EPC STORMWATER REVIEW COMMENTS ARE SHOWN IN ORANGE BOXES WITH BLACK TEXT

Post Construction Stormwater Management Applicability Evaluation Form

Part I. Project Information	
1. Project Name: Saddlehorn Filing 3 Ponds C E	Filings 3 & 4 Early Grading (unresolved)
2. El Paso County Project #: EGP-22-224	3. ESQCP #: EGP-22-004 (unresolved)
4. Project Location: Southwest corner of Judge Orr Rd & Curtis Rd	Project Location in MS4 Permit Area (Y or N): N
5. Project Description: Saddlehorn Filing No. 3 is a proposed 179 acre development consisting of 44 large lot single family residences with associated roads, utilities, open space, and other infrastructure in El Paso County.	
If project is located within the El Paso County MS4 Permit Area, please provide copy of this completed form to the Stormwater Quality Coordinator for reporting purposes; and save completed form with project file.

PERMANENT BMP APPLICABILITY

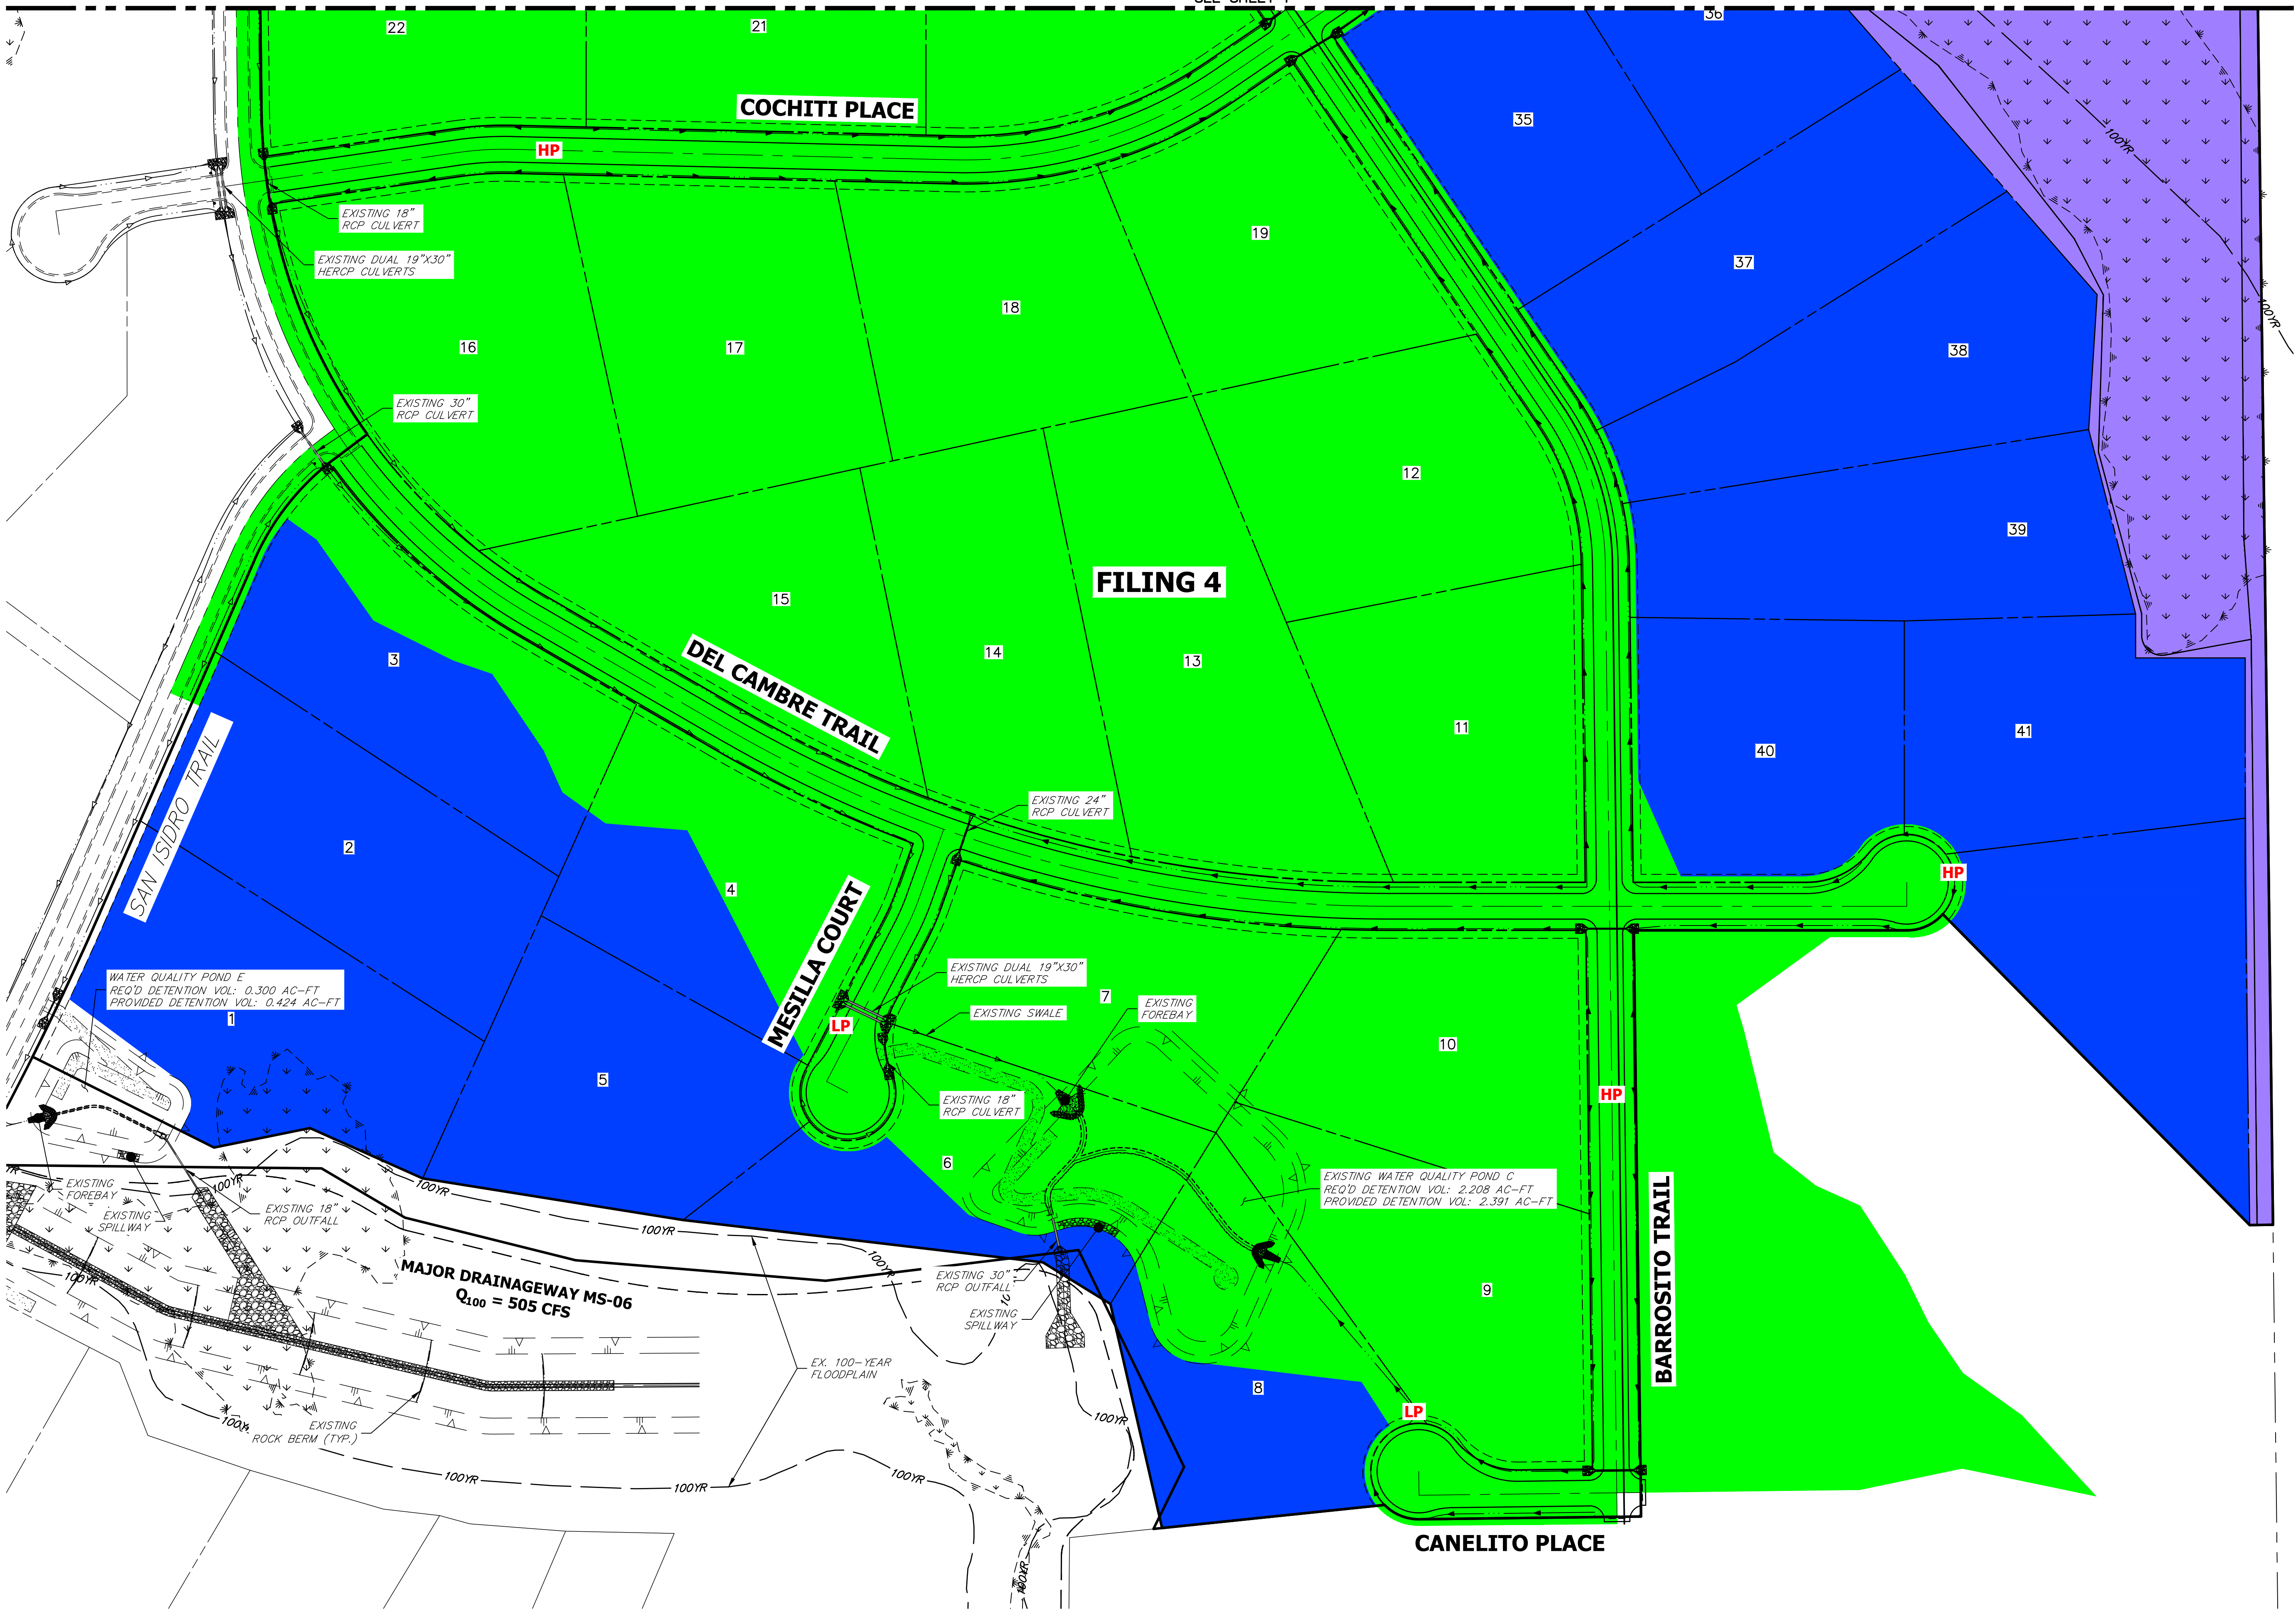
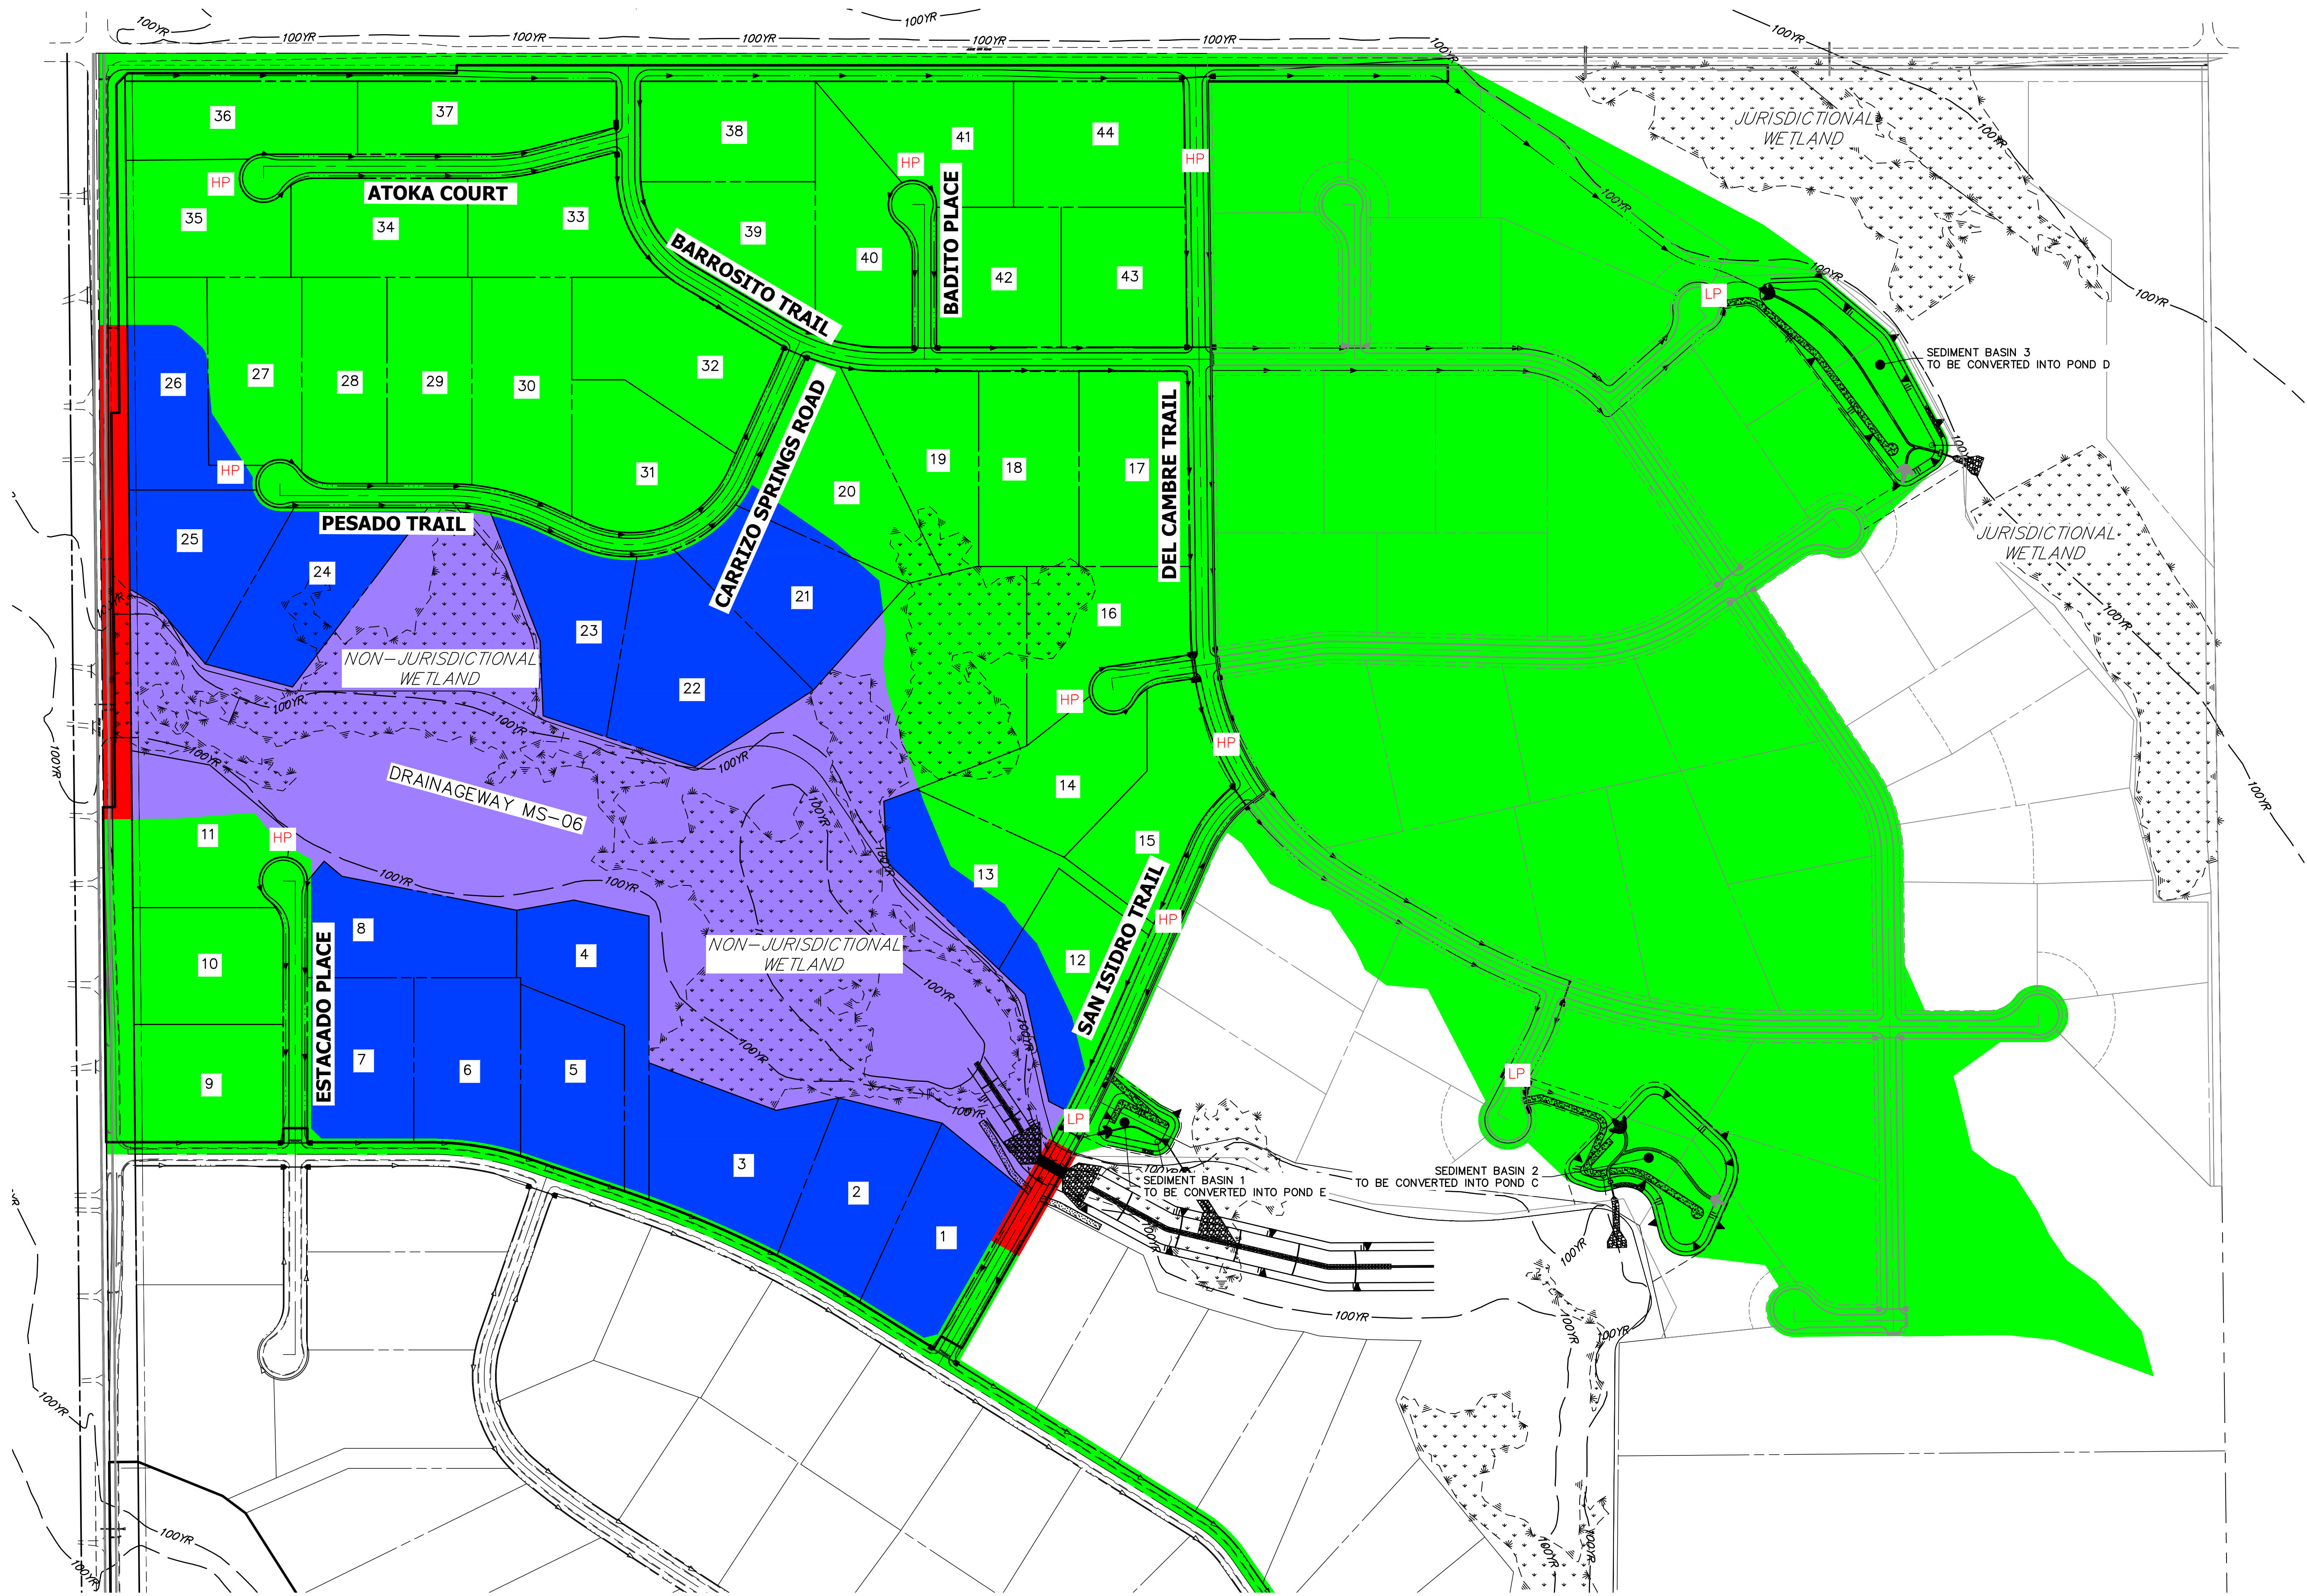
Change to something along these lines and attach figure:
 Stormwater will be treated via Temporary Sediment Basins AND/OR existing Ponds C, D, and E. All areas to be treated by the ponds and all MS4 Permit Exclusion areas are shown on the attached figure.
 Unresolved.
